From: Martin Critchley [REDACTED]
Sent: 20 April 2018 10:16
To: Daun Johnson
Subject: Re: Further Information Required on Your Ref: PP-06832157 Our Ref: A/48/18/HH

Subject: Re: Further Information Required on Your Ref: PP-06832157 Our Ref: A/48/18/HH

SITE PLANS

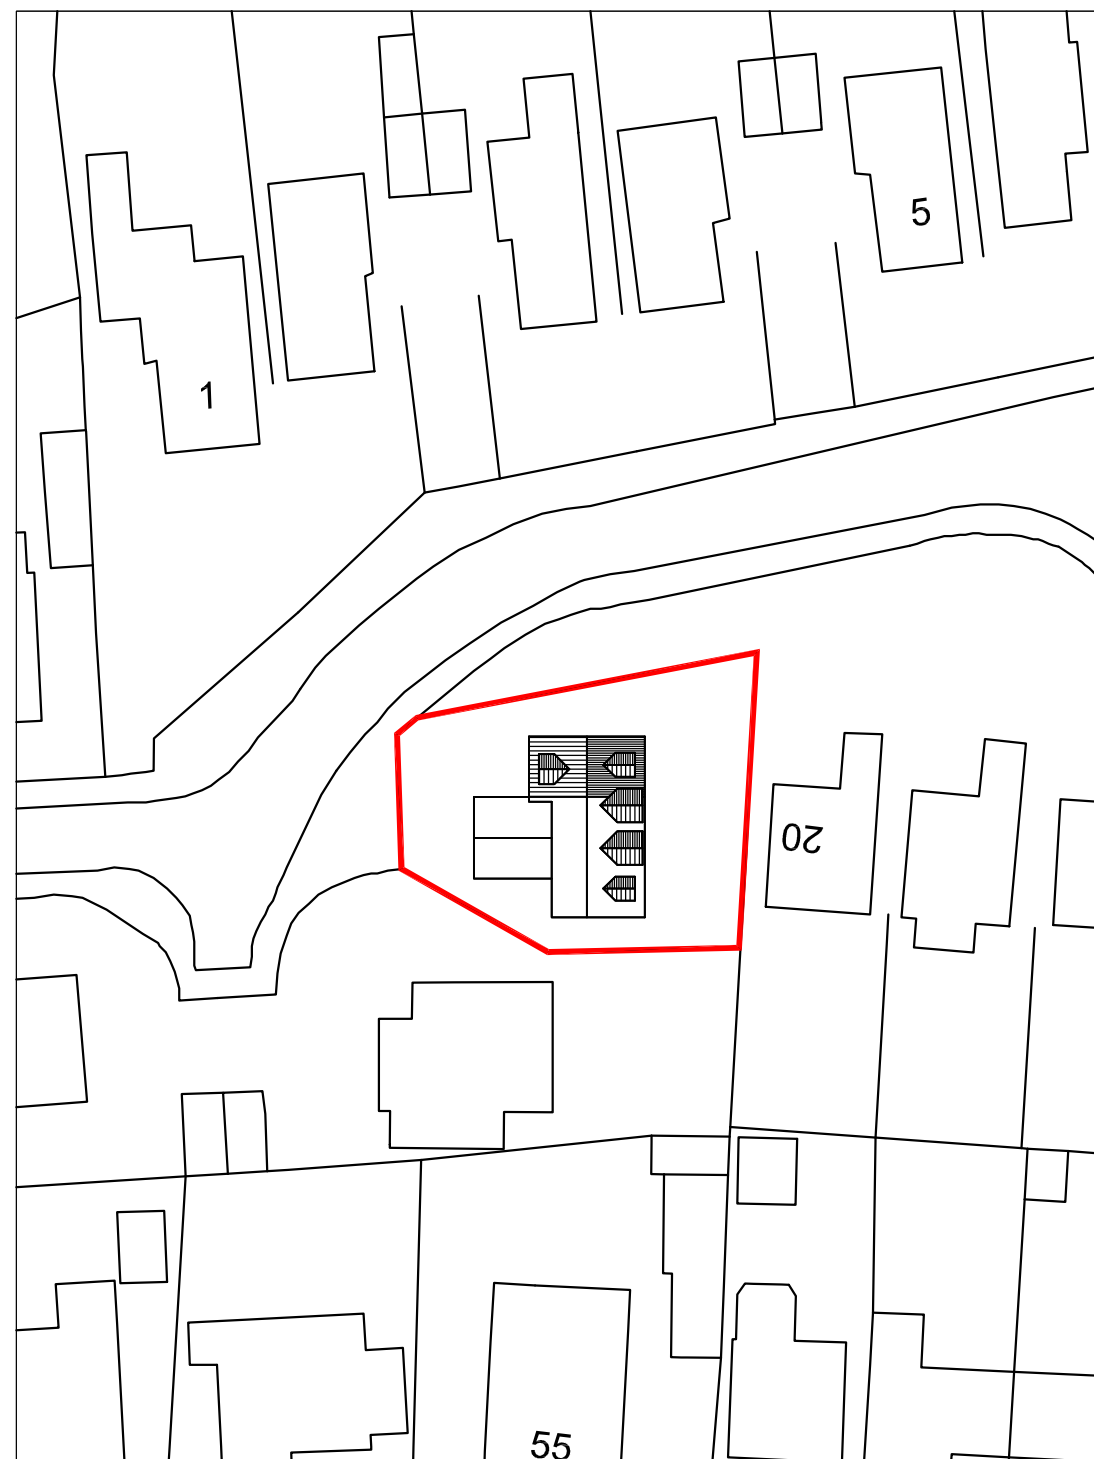
The Block Plan should already show the extent of the proposed roof. Is this OK?

PROPOSED
PLAN &
SECTION

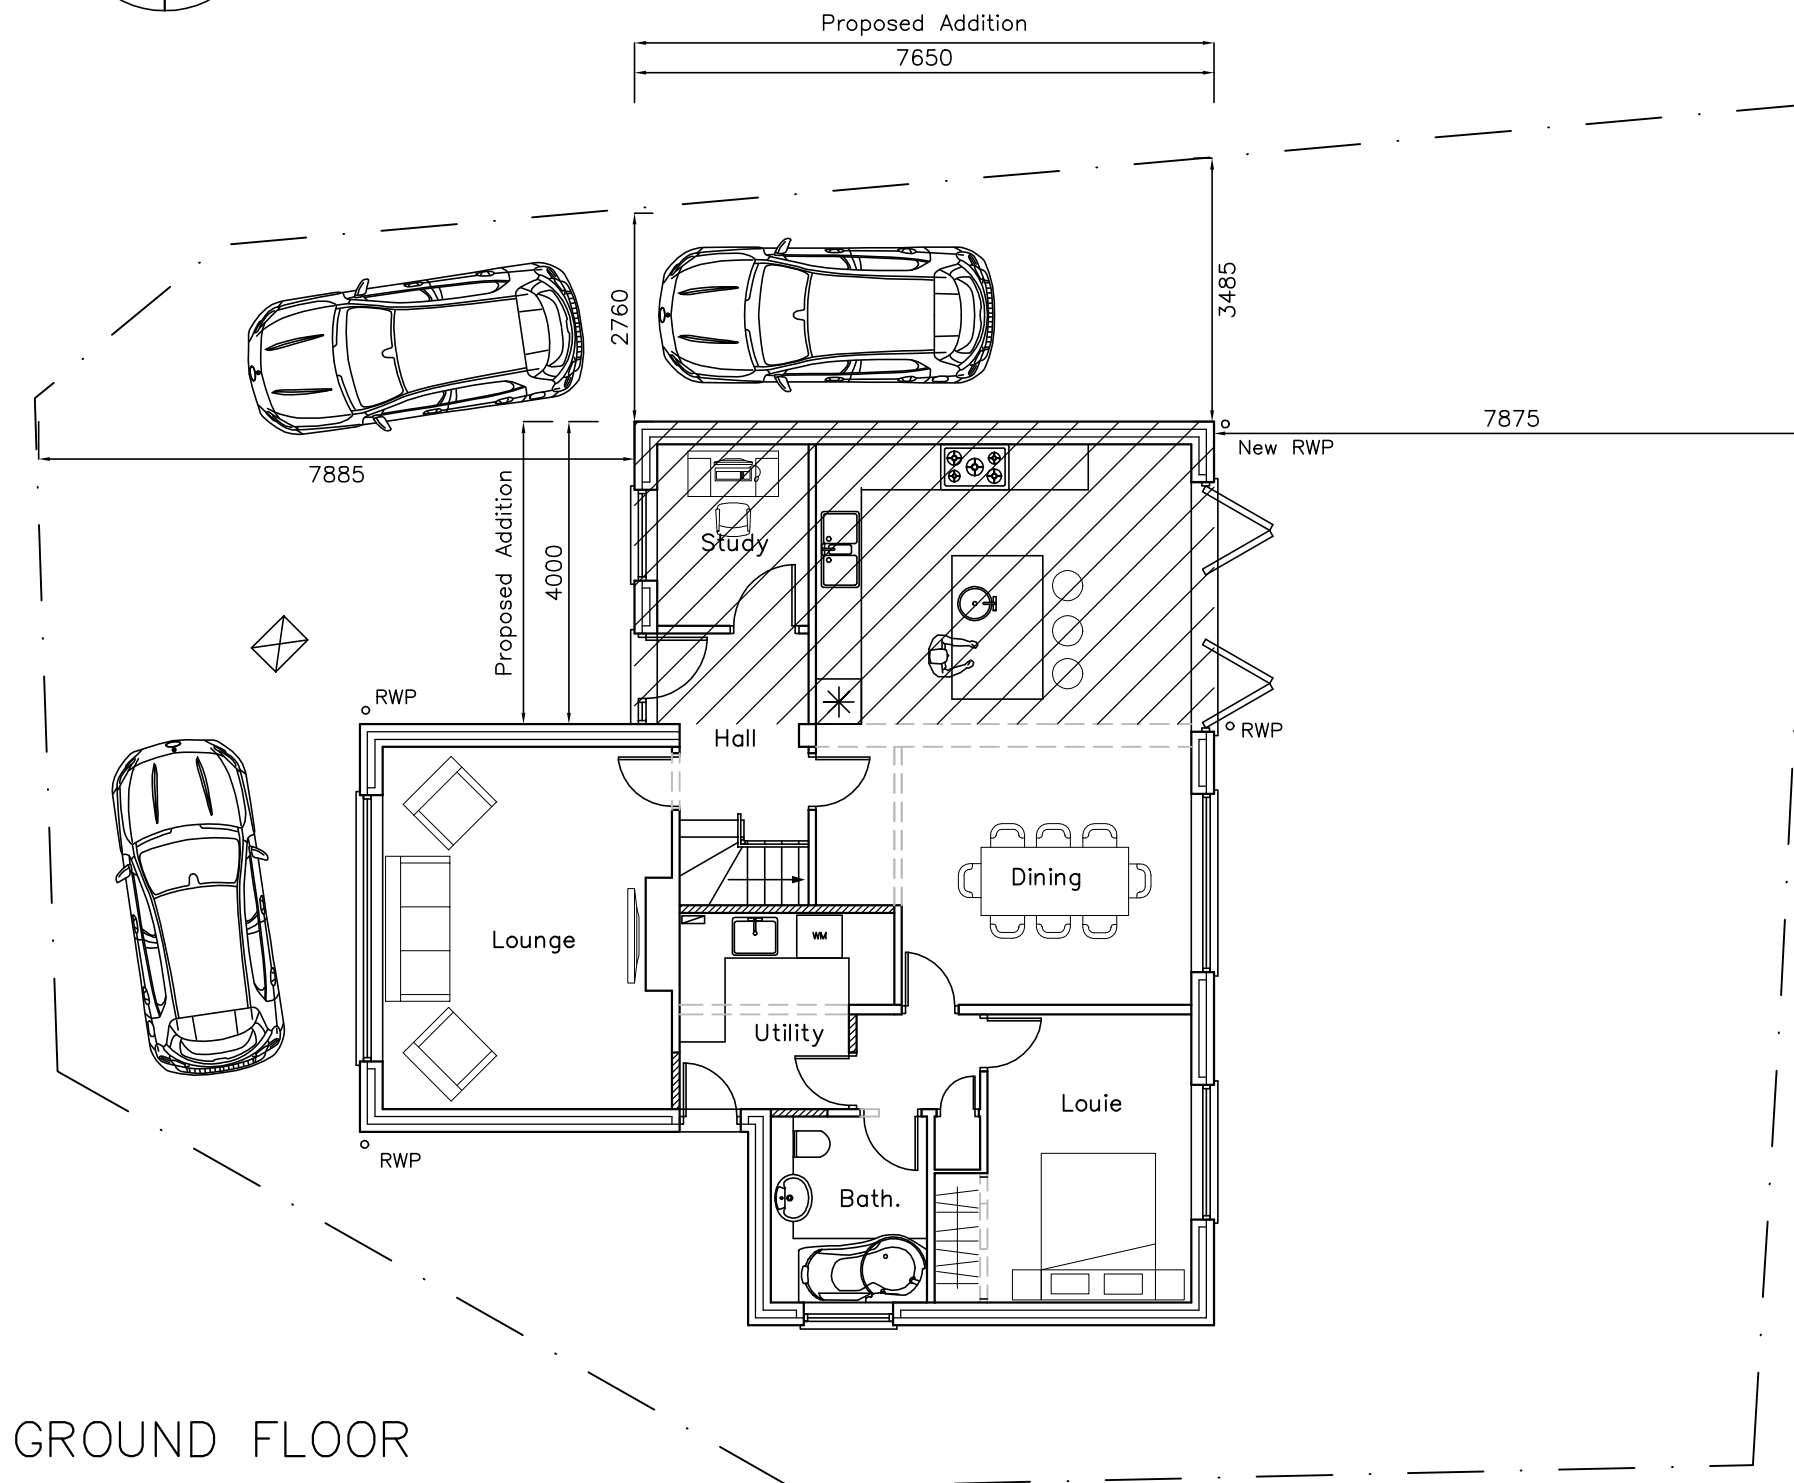
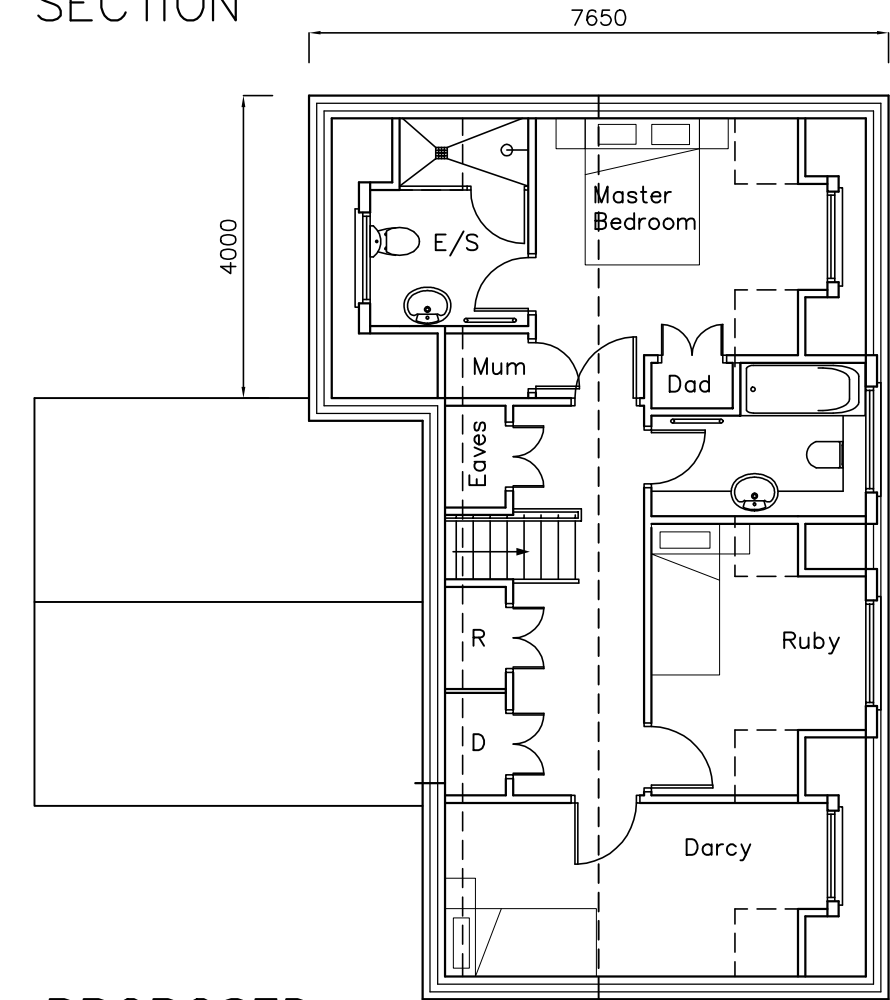
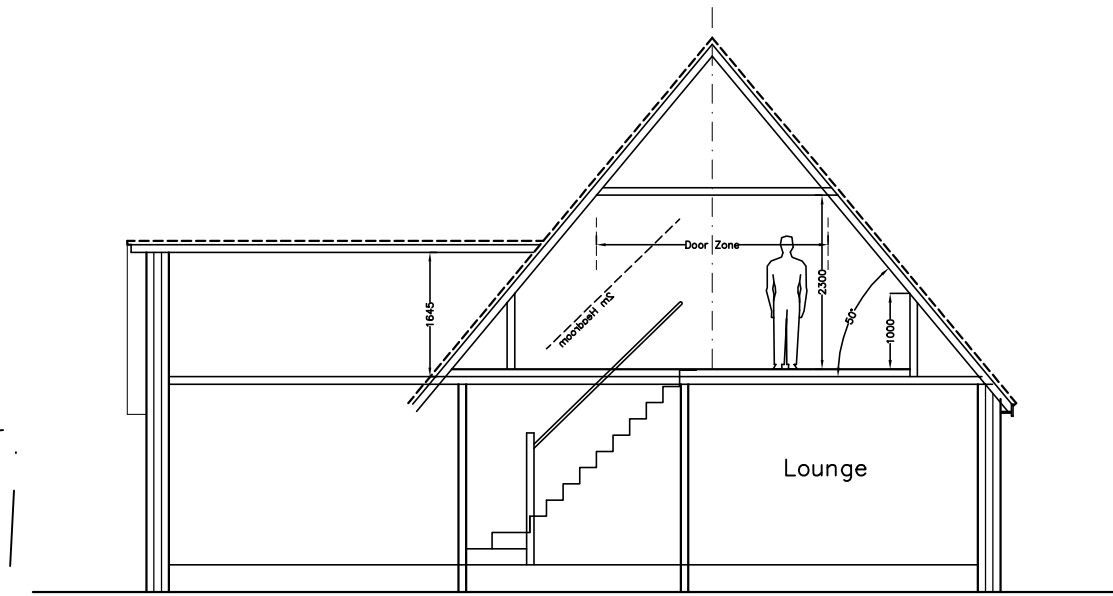
We have added the boundary dimensions to the 1:100 Proposed Floor Plans, as they are somewhat easier to read at this scale and the proposed works and boundary are already clearly marked. A copy of this drawing is attached.
